Application for Removal or Variation of a Condition following Grant of Planning Permission or Listed Building Consent

Demolition and replacement of the existing detached house and outbuildings, with a new detached dwelling, new wrought iron gates, brick piers and low level brick walls; slight alteration of one of the existing access and crossover points with retention of the other existing access; and associated ancillary works.

51186/APP/2020/4149

1363/P/1B, 2A, 3A, 4A, 7C, 8B & 10A

rev:	date:	description: 0.343 ha	
scale: 1 : 250	A1	date: 12 / 11 / 2020	
drawing no:	1363 / P / 1 ^B		drawn: FJ

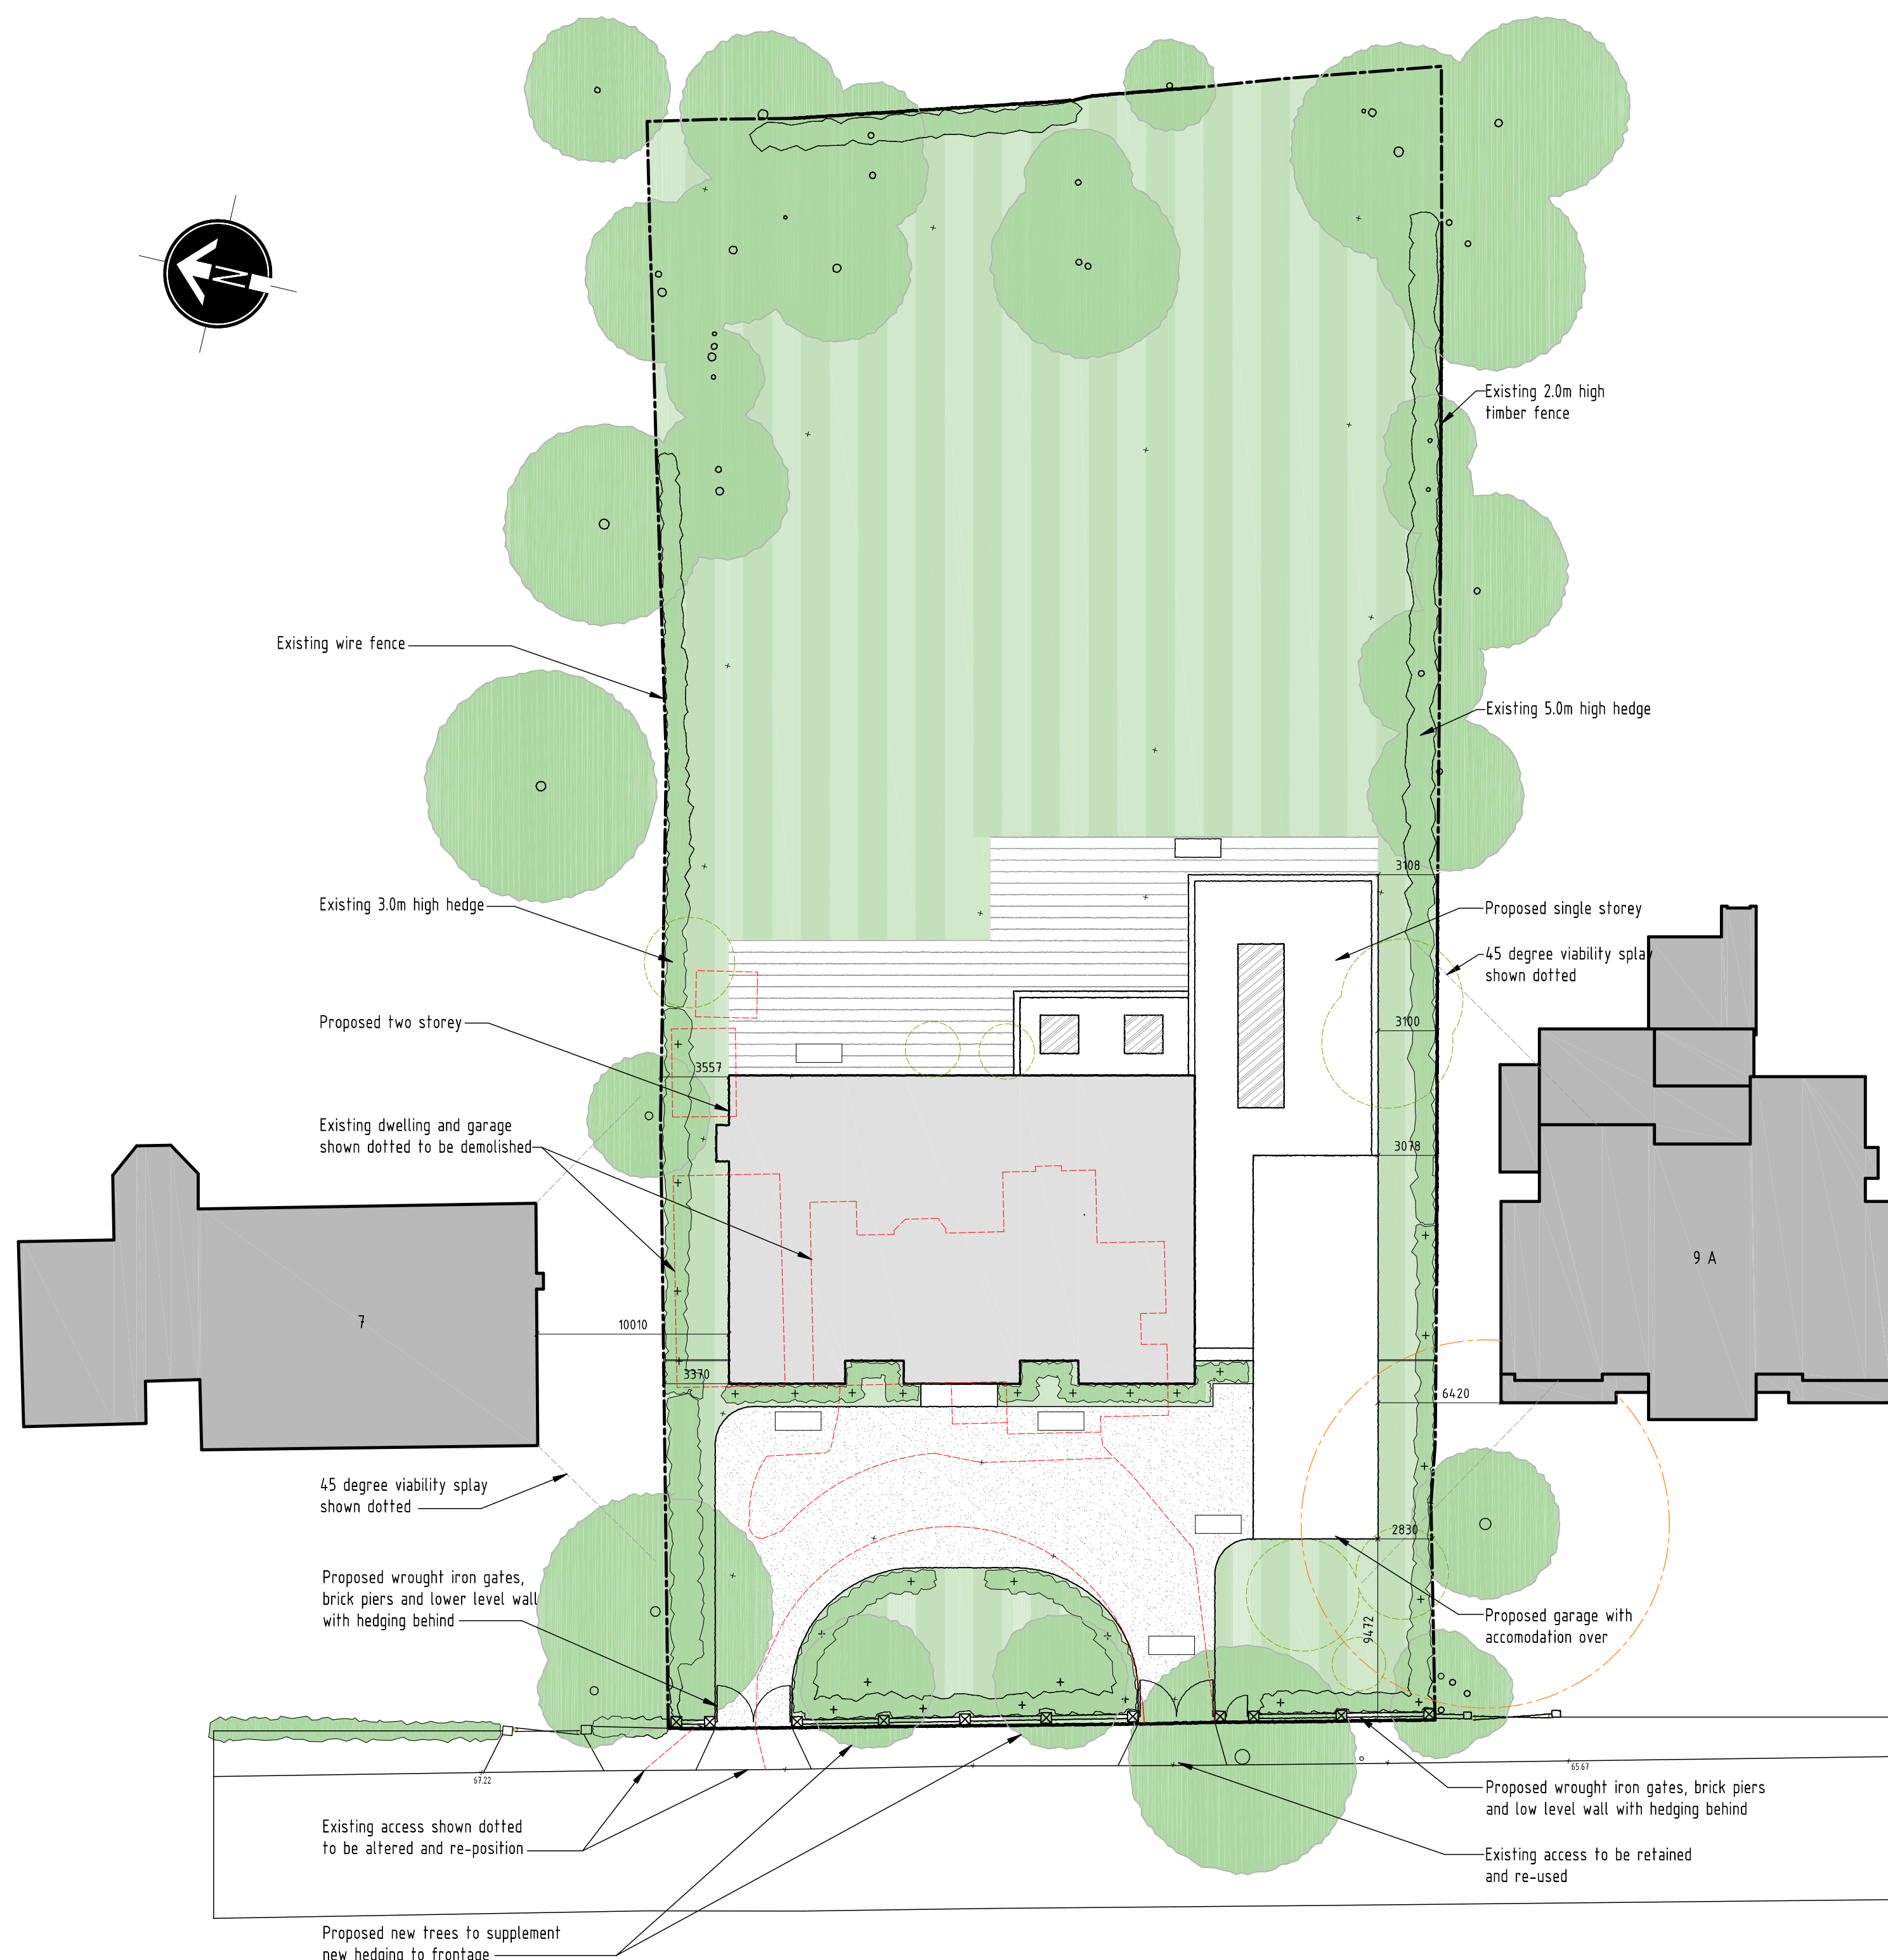
- Single storey rear projections have been reconfigured resulting in a reduction in area of 22m2.
- Glazing reconfigured to rear and flanks, with a reduction of 10%.
